Charlotte Department of Transportation

Memorandum

Subject: Rezoning Petition 08-055: Located on the east side of East W.T. Harris Boulevard between Old Concord Road and Back Creek Drive

University East Mixed-Use Site

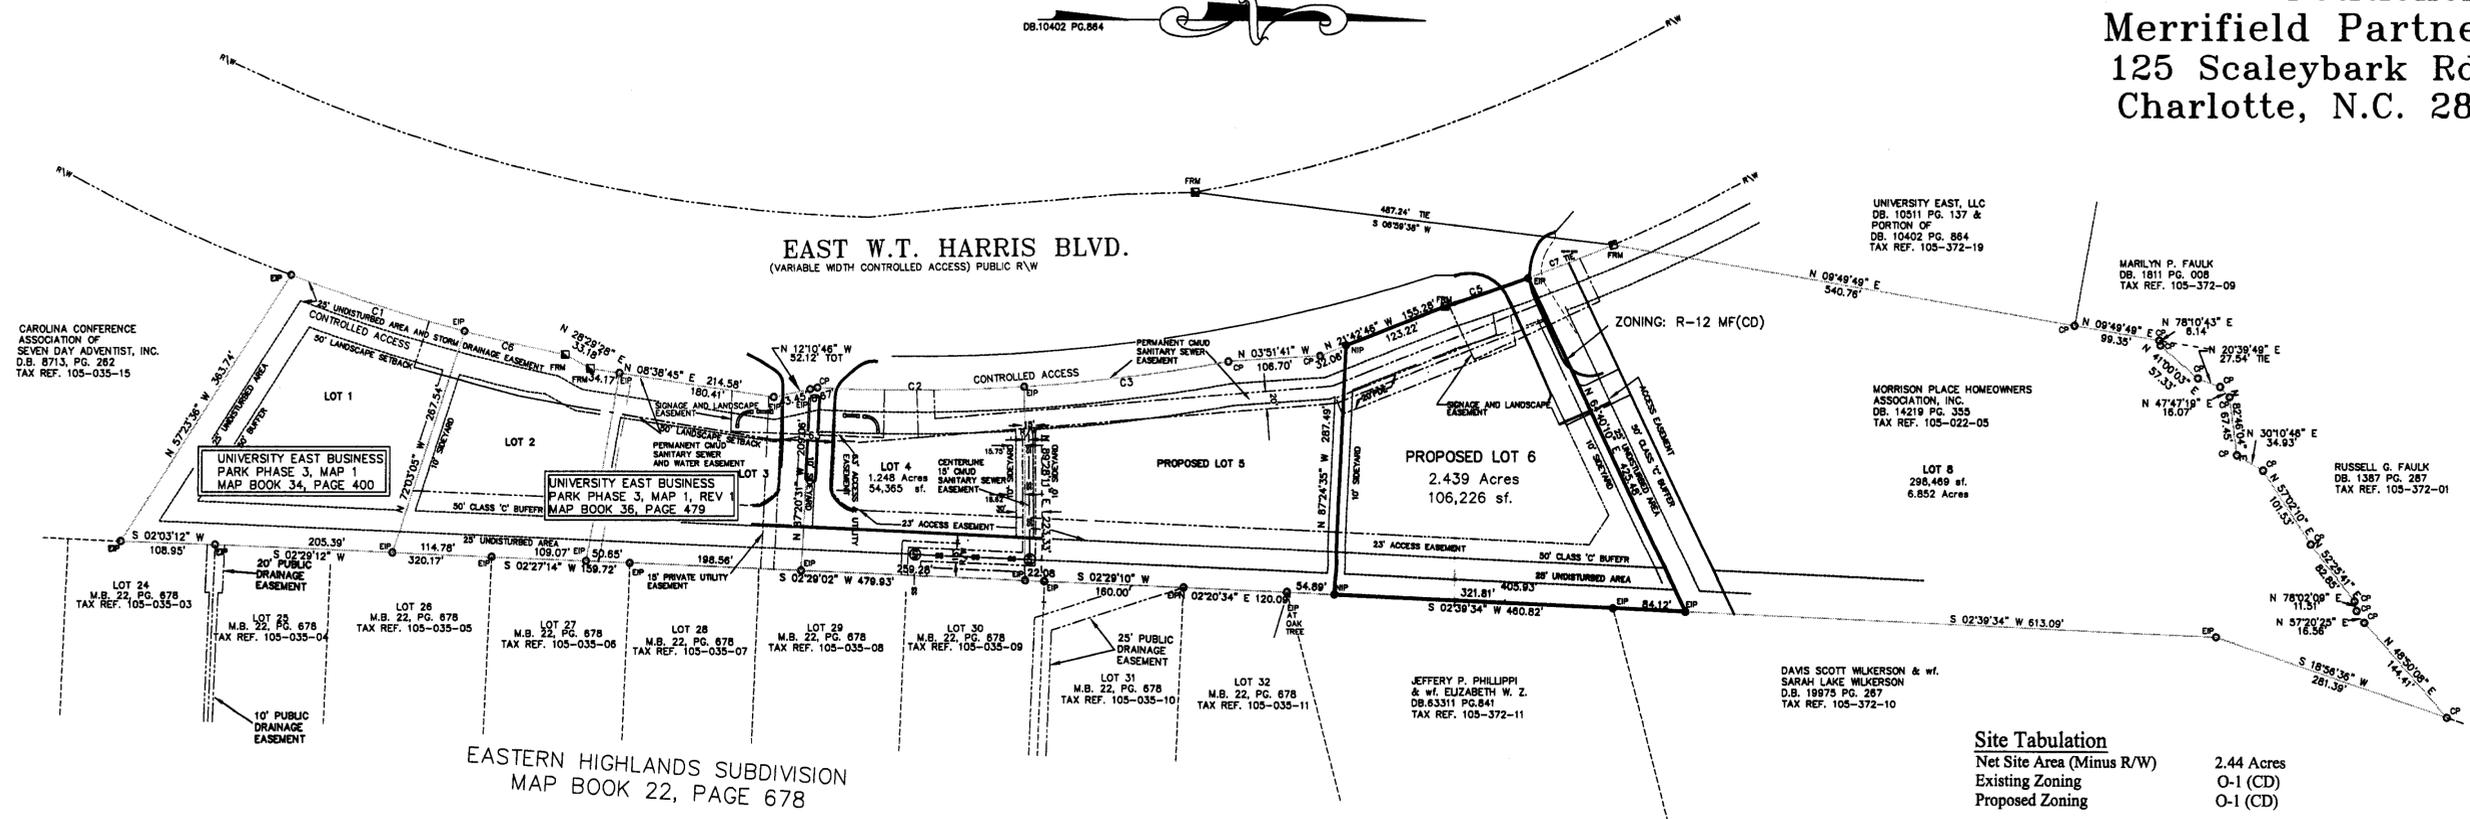
1. The site must use existing access points. No additional access onto WT Harris Boulevard will be permitted.

1. The pedestrian path that exists along the frontage adjacent to the site to the north should be continued across this property frontage.

Adequate sight triangles must be reserved at the existing/proposed street entrance(s). Two 35' x 35' and two 10' x 70' sight triangles are required for the entrance(s) to meet requirements. All proposed trees, berms, walls, fences, and/or identification signs must not interfere with sight distance at the entrance(s). Such items should be identified on the site plan.

- All City of Charlotte Land Development Standards (latest revision) will apply.
- Indicate the locations and widths of all adjacent and opposing driveways.
- Indicate typical parking module dimensions.
- Directional wheelchair ramps (two per corner) should be provided at all intersections of public and private streets.
